CITY OF ALBUQUERQUE

April 8, 2008

**Re: Yearout Mechanical Warehouse, 8501 Washington St. NE,
Approval of Permanent Certificate of Occupancy (C.O.),
Engineer's Stamp dated 09/19/07 (C-17/D001U10)
Certification dated 4/07/08**

1 SITE PLAN

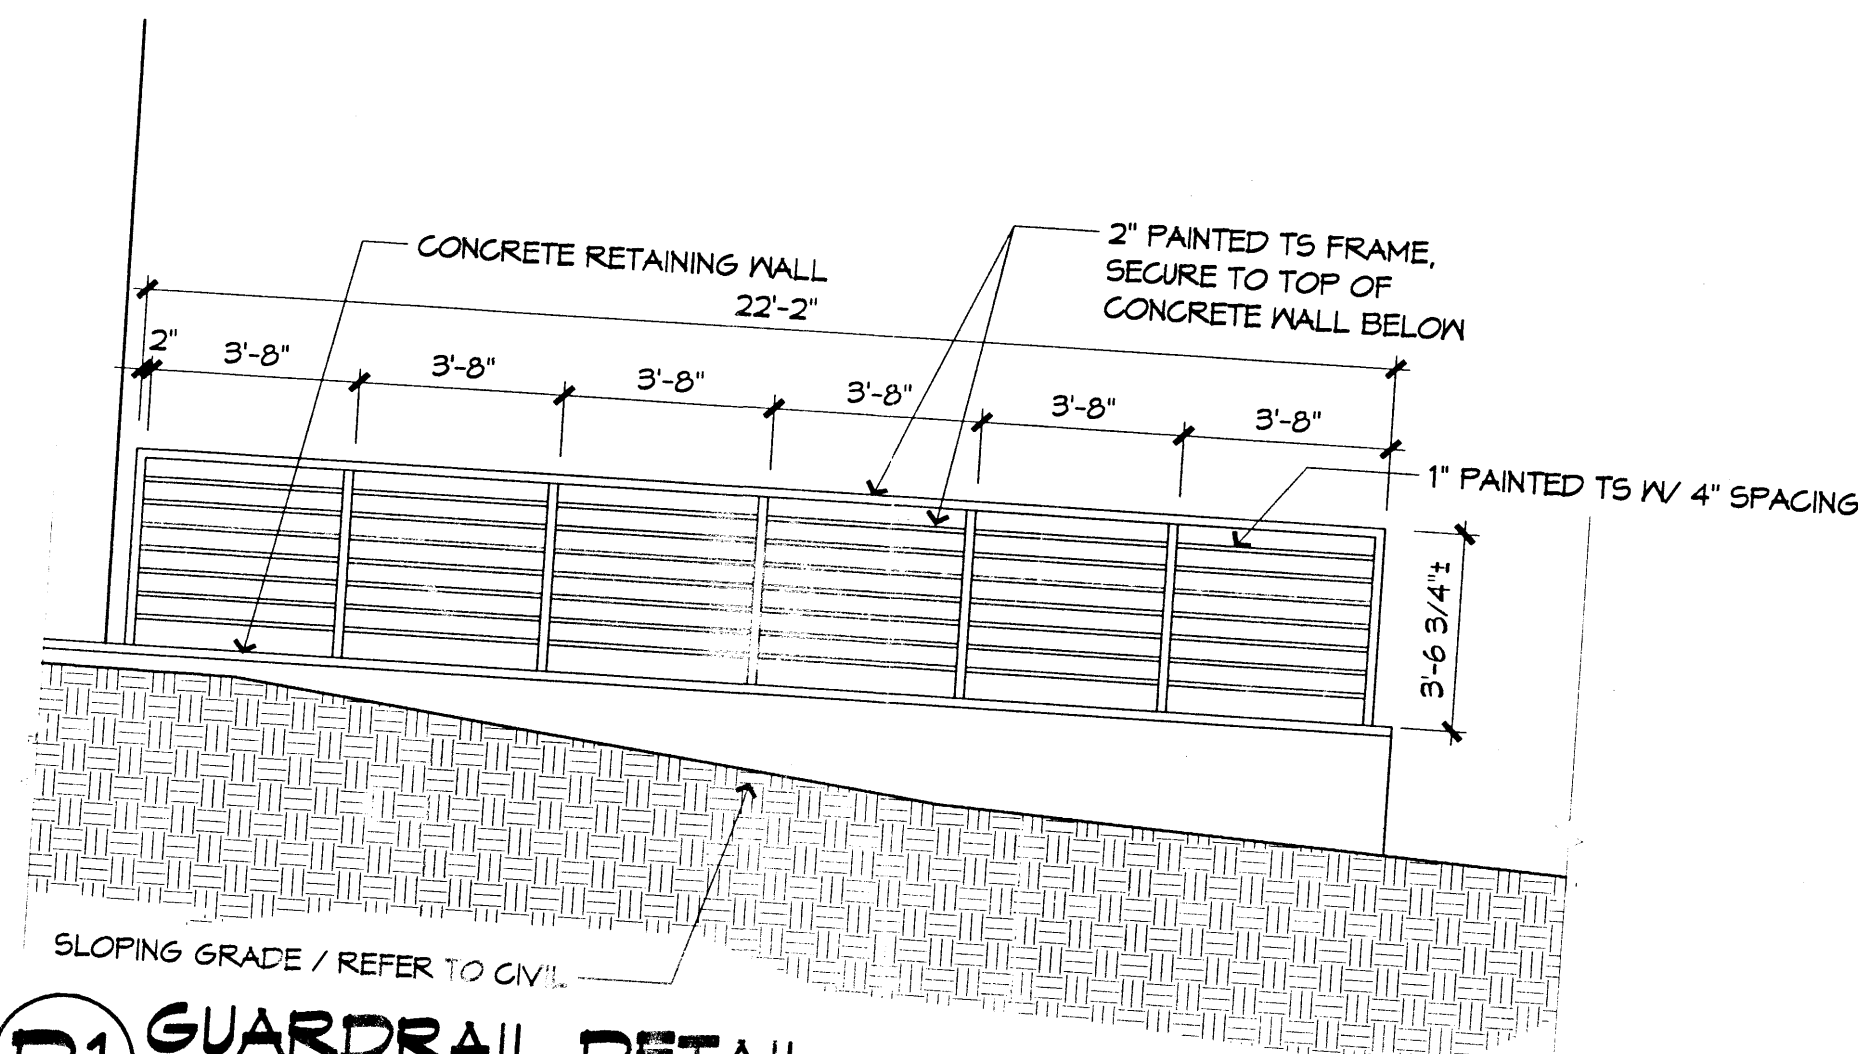
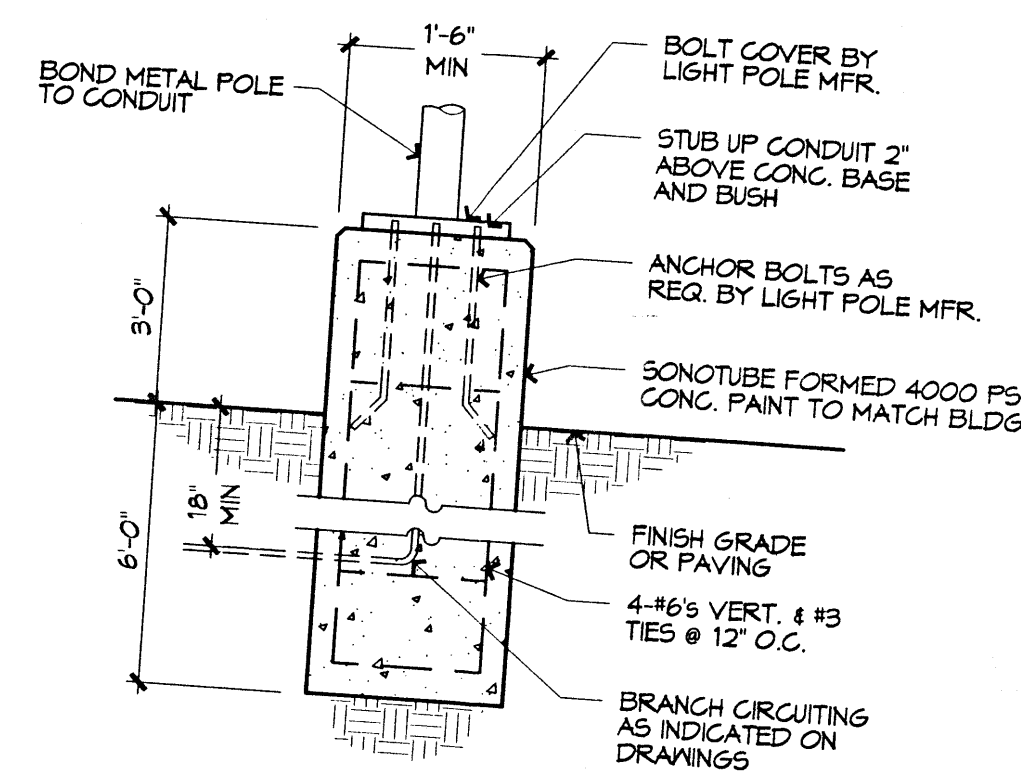
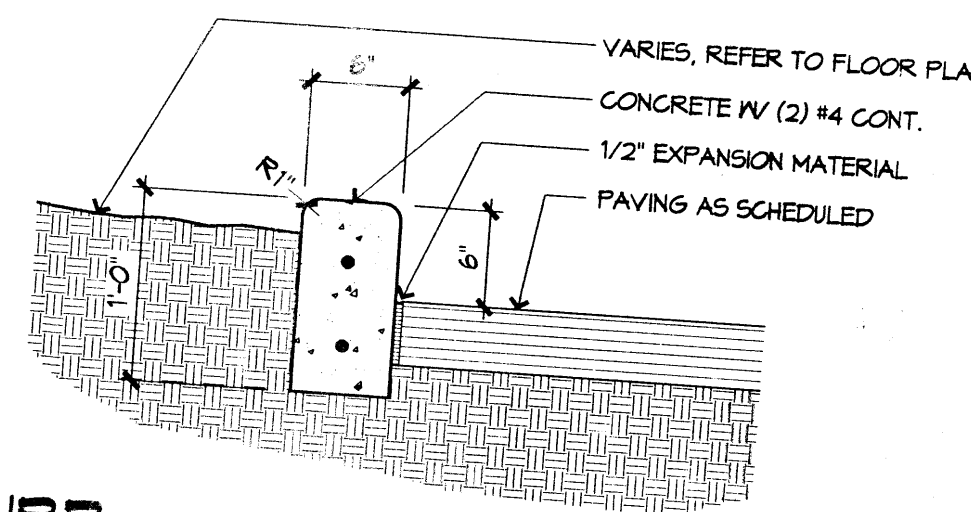
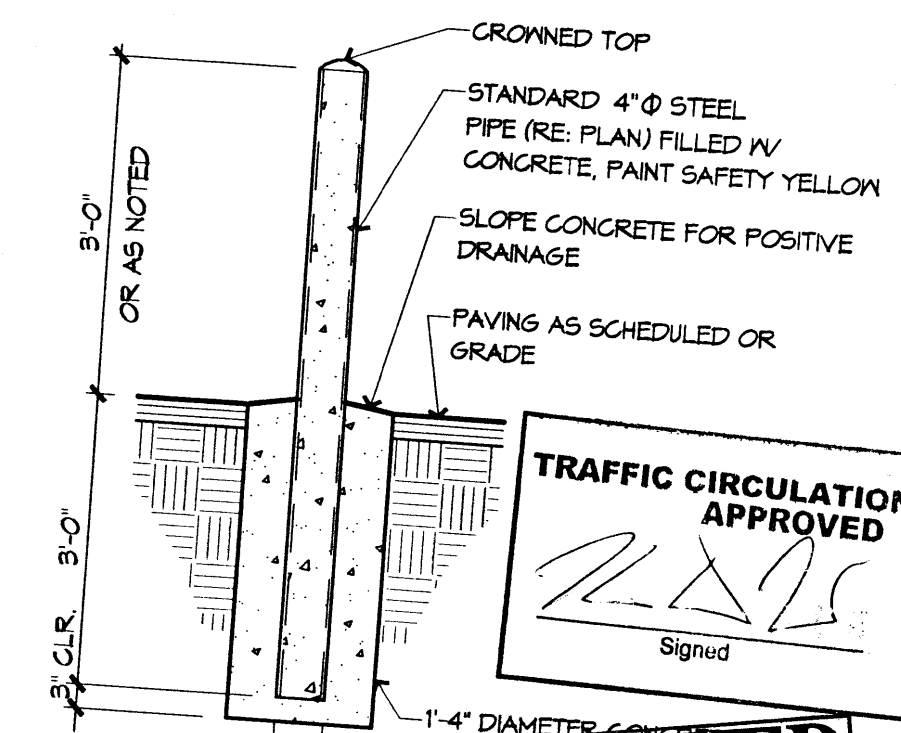
1. For passenger vehicles, the minimum end island radius is 15 feet. This radius is needed at the one-way entrance and the entrance off of Washington Place and at the one-way on Washington Street.
2. Please ensure all ramps are ADA compliant.
3. One-way signage and striping will be required at the one-way entrances and exits.
4. It appears the sidewalk overlaps the property line; therefore, a sidewalk easement is needed for the sidewalk along Washington Street.
5. Remove "some" from note #24. All wheelchair ramps within the City Right-of-Way require truncated domes; also amend the northern most drive-way note to truncated dome in lieu of "half dome."
6. Detail the operation of the gate. Will the gate only be open during business hours or will the gate stay closed?

1. List radii for all curves shown.
2. For passenger vehicles, the minimum end island radius is 15 feet.
3. List the width and length for all proposed parking spaces.

4. Per the *Development Process Manual*, Chapter 27, Section 1, "Standard sheets must be 24" by 36" having a margin of 2" along the left and 1" on the top and bottom."

5. Please show the location of the nearest driveways on the adjacent lots.
6. Define the distance between the drives on Washington Street.
7. Show a vicinity map on the plan.

8. List the number of parking spaces required by the zoning code as well as the proposed number of parking spaces.
9. Per the *Development Process Manual*, Chapter 27, Section 7, Part F.II, a scale of 1"=20' is recommended for sites of less than 5 acres. Please note that, per the *Development Process Manual*, Chapter 27, Section 2, Part B.1, only the following scales may be used:

- 1" = 50'
 - 1" = 40'
 - 1" = 20'
 - 1" = 10'
 - 1" = 100' (for overall layouts only)
10. The southernmost entrance on Washington Street does not appear to meet City Standards. Please provide additional geometric information for this drive. How will a ramp be fitted into this drive?

11. Show all sidewalk, both existing and proposed, on the plan. Please note that all proposed sidewalk should be placed at the property line, not the back of curb. Call out the width of all sidewalk.

12. Please refer to all applicable city standards, by city standard number, on the plan.

- 13. Please include two copies of the traffic circulation layout at the next submittal.
- 14. List the width of all driveways. To accommodate ADA standards, all driveways must have a 3-foot wide pedestrian access path. This path must have a cross slope of no greater than 2%.
- 15. Please ensure all ramps are ADA compliant.
- 16. Clarify the extents of the current phase.
- 17. Will this building require a pedestrian path? Please check with the zoning department regarding this.
- 18. I understand that a re-plat of this site is currently in process with the Development Review Board. Therefore, any comments regarding required easements will be postponed until the proposed plat has been approved. Include a copy of the recorded re-plat with the next submittal.

I believe that I have answered all your concerns in regards to the TCL for Yearout Mechanical Warehouse. I do however; have questions in regards to your comments #11 and #18.

Comment #11 asks for our side walk to start at the property line and not at the back of curb. There is an existing 10'-0" utility easement that starts along the property line. There are full mature trees planted on a slope up to the street (at the far south end there is 4'-0" retaining wall in place). There is also a precedent in that, all other sidewalks in this industrial park are all pushed out to the curb. I am showing a new 6'-0" side walk next to the curb to keep with other surrounding properties, easy of construction on the slope and to save the existing trees. (Please see attached labeled photos).

Comment #18 asks for a recorded re-plat with our next submittal. Wilfred who reviewed this plat first, asked for the sidewalk along Washington Street stated that he would not approve the plat until we added the sidewalk and got an approved TCL. I know there has been a change in personnel in your office so I don't know what should come first.
